CITY OF PORTLAND BUILDING PERMIT

PERMIT ID: 2013-00076

has permission to **Renovate kitchen & bathroom; replace windows, etc. Convert screen porch to mudroom/pantry.**

Dept: Historic **Status:** Approved w/Conditions **Reviewer:** Robert Wiener **Approval Date:** 02/11/2013**Note:** Fenestration in the mudroom pantry area (existing screened porch) has been revised in 2/6/13 submission. A new condition has been added since the Historic Preservation Certificate of Appropriateness was approved with conditions on 2/4/2013, in response to the plan revision. **Ok to Issue:** ☒

**FIRST FLOOR PLAN**  
 1/4" = 1'-0"

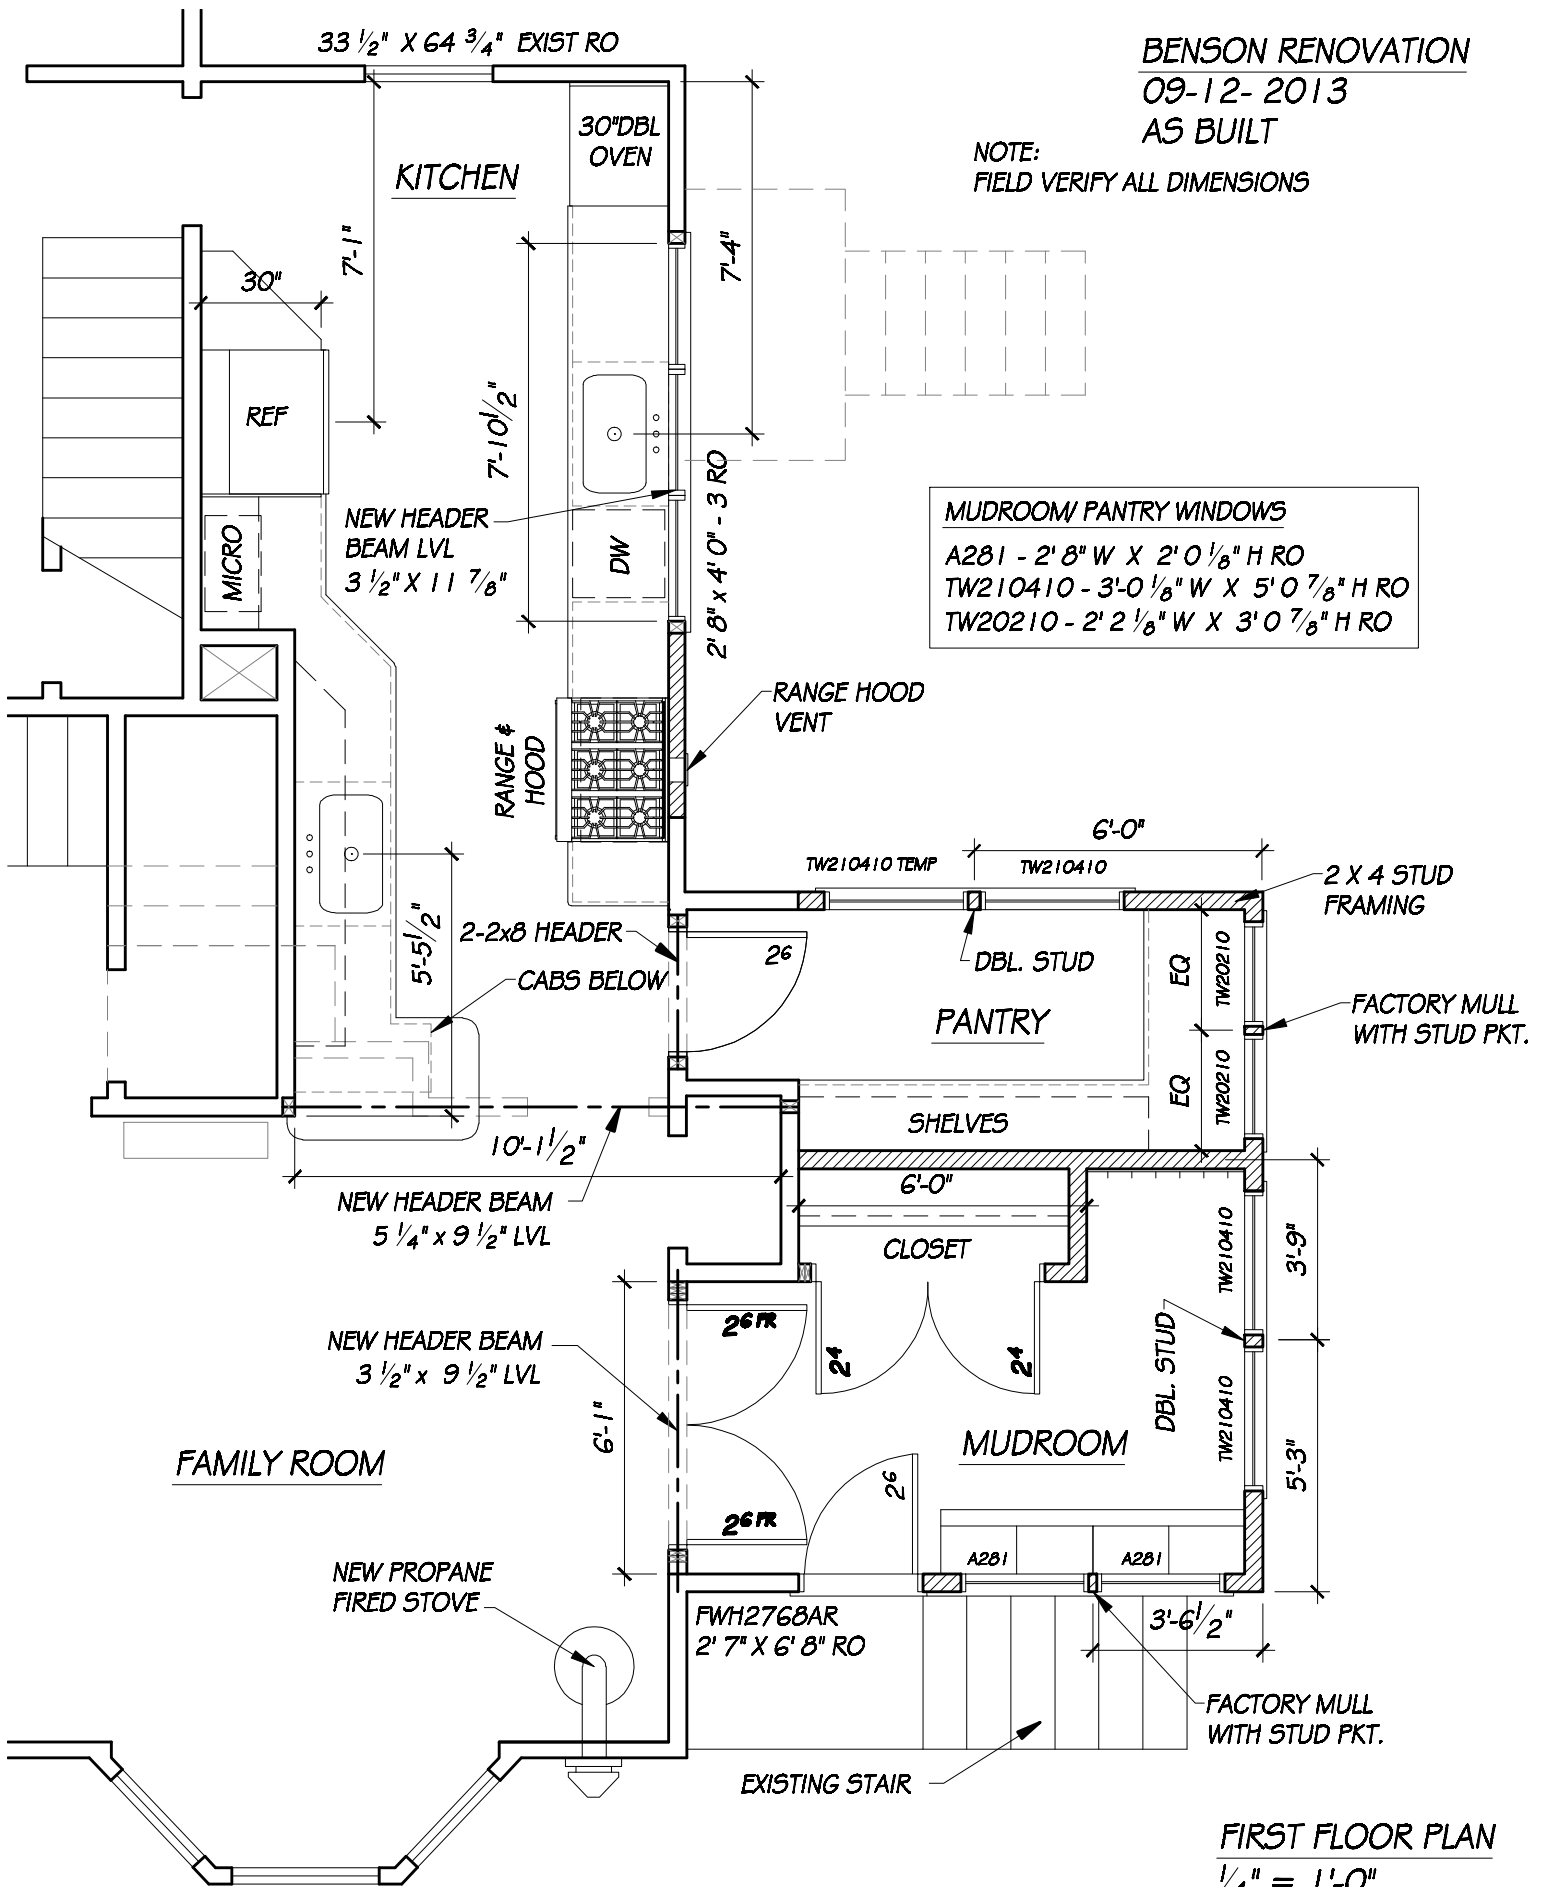
- 8) 8. The two awning windows shown on the east wall of the mudroom in the 2/6/13 revised plan are to match the wood windows manufactured by Windsor which are approved to be installed in the main part of the house. (All windows visible from a public way are to be of the same type, configuration, and material - wood.)
